Agent Ref 10029608 -PM Mawer, Tenant Ref 10029607-GL Riby
Land at High and Low Stonehills Farms and Low Farm Barmston – Yorkshire and Humber CCS
pipeline proposal for DCO

WRITTEN REPRESENTATION

Application for Development Consent Order (DCO)

**YORKSHIRE & HUMBER CCS CROSS COUNTRY PIPELINE
EN070001**

DRG No **10-2574-PLN-01-0340**

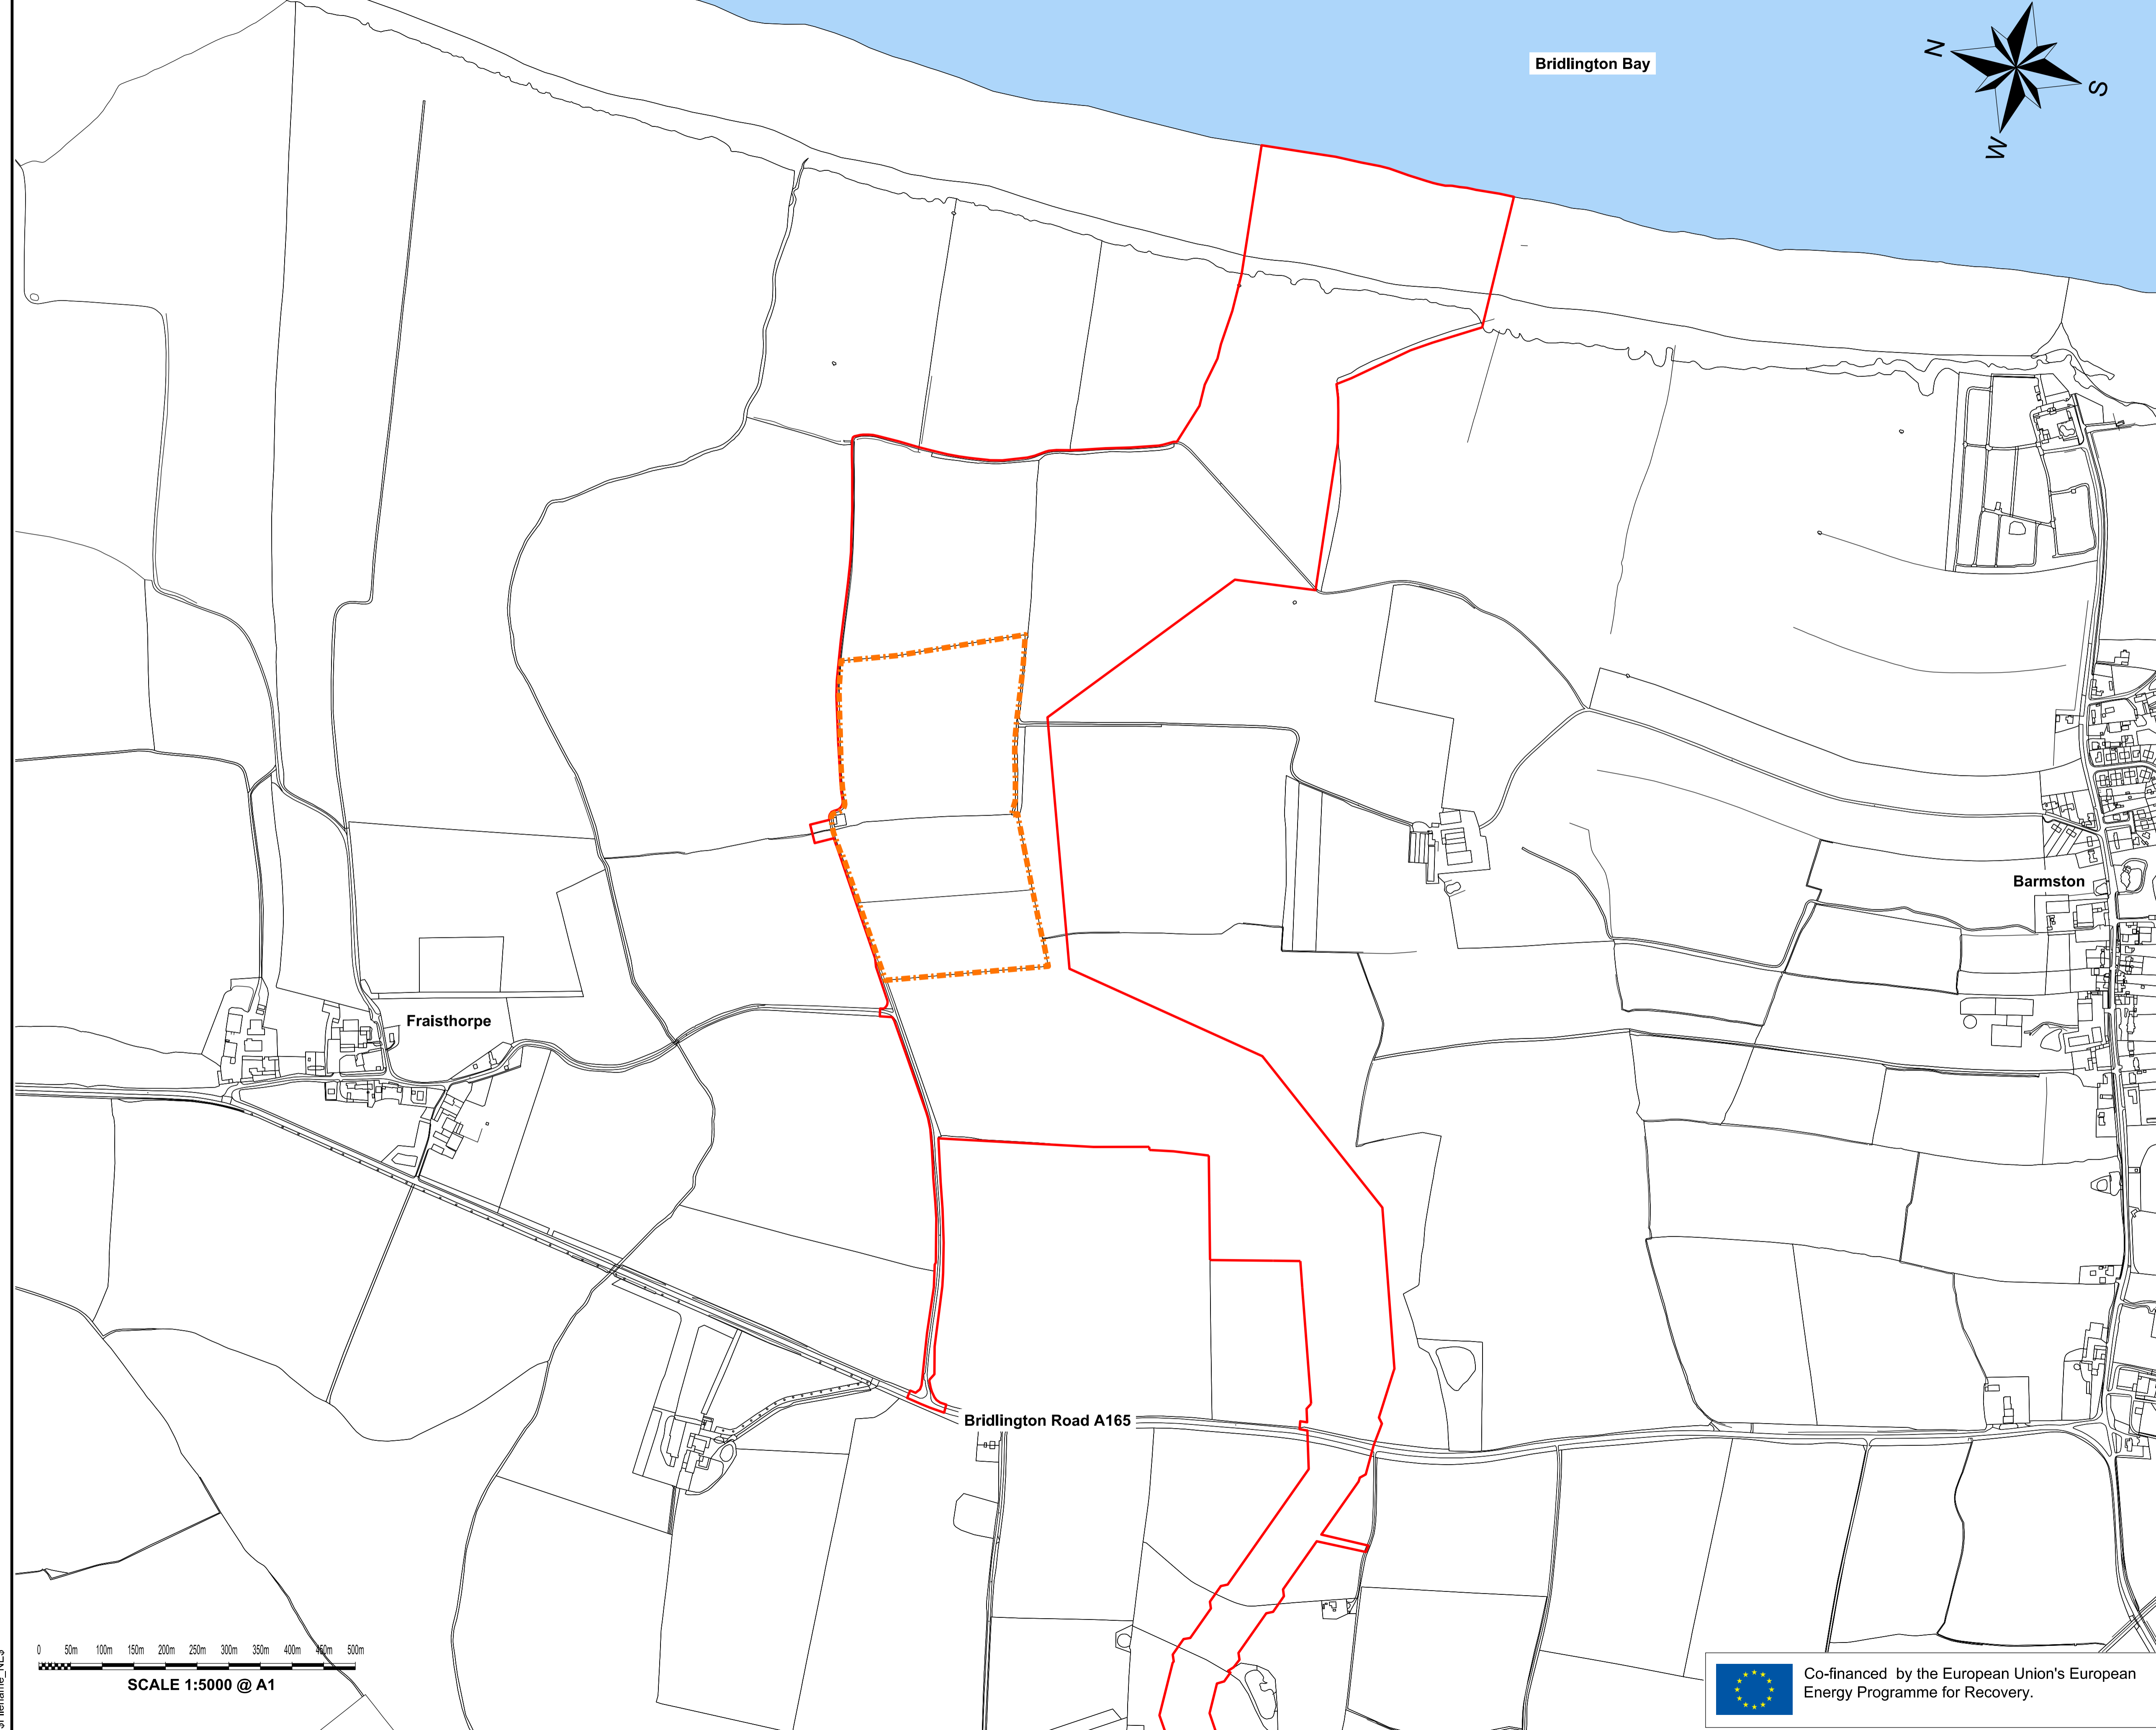
- The Developer has moved the Pumping station site at the request of the landowner to arrive at the proposal location.
- One of the reasons for this suggestion was that the site would be nearer a public road for construction access purposes (the 'back' road to Fraisthorpe village) being accessible directly from the A165

- Despite this being a single track road the distance between hedges is sufficiently wide to install temporary or permanent passing places along its length and visibility at the Highway junction is likely to be better than the proposal access.

- The proposal requires access for all heavy construction traffic along the working strip to be taken along the pipeline route between the A165 and the proposed pumping station

- This means that heavily laden vehicles and heavy machinery will access the Pumping station site across agricultural land with surfacing works to try and prevent such heavy traffic from becoming bogged down

- The weight of such traffic will have serious and long reaching implications for soil structure along this part of the pipeline route once returned to agricultural use, no matter what assurances are given by the developers regarding reinstatement.

- **All construction vehicle access and subsequent access to the Pumping Station site should be via the single track public highway from the A165 at the junction nearest Stonehills Cottages with suitable improvements to passing places added by the developer where necessary.**
